**Application No:** 23/03020/FULL  
**Proposal:** Erection of domestic garage  
**Address:** 79 Hope Street Inverkeithing Fife KY11 1LN

I acknowledge receipt of your application for Full Planning Permission dated 26th October 2023. However, I regret I cannot accept your application as valid for the following reasons:-

# BLOCK PLAN 1:500

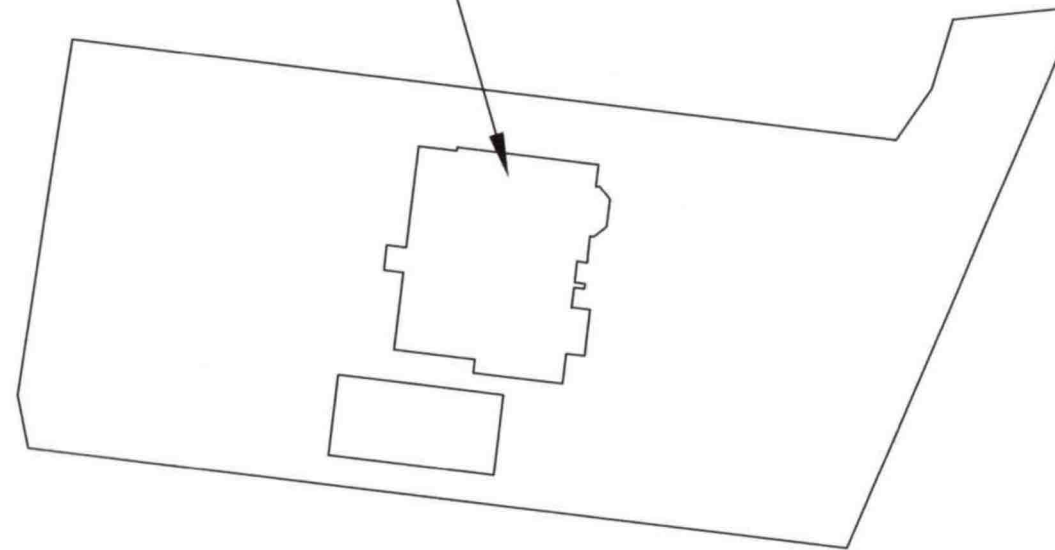
2. Your block plan did not contain a 1:500 scale bar to allow the drawings to be calibrated. Please submit replacement plans with an accurate scale bar annotated.
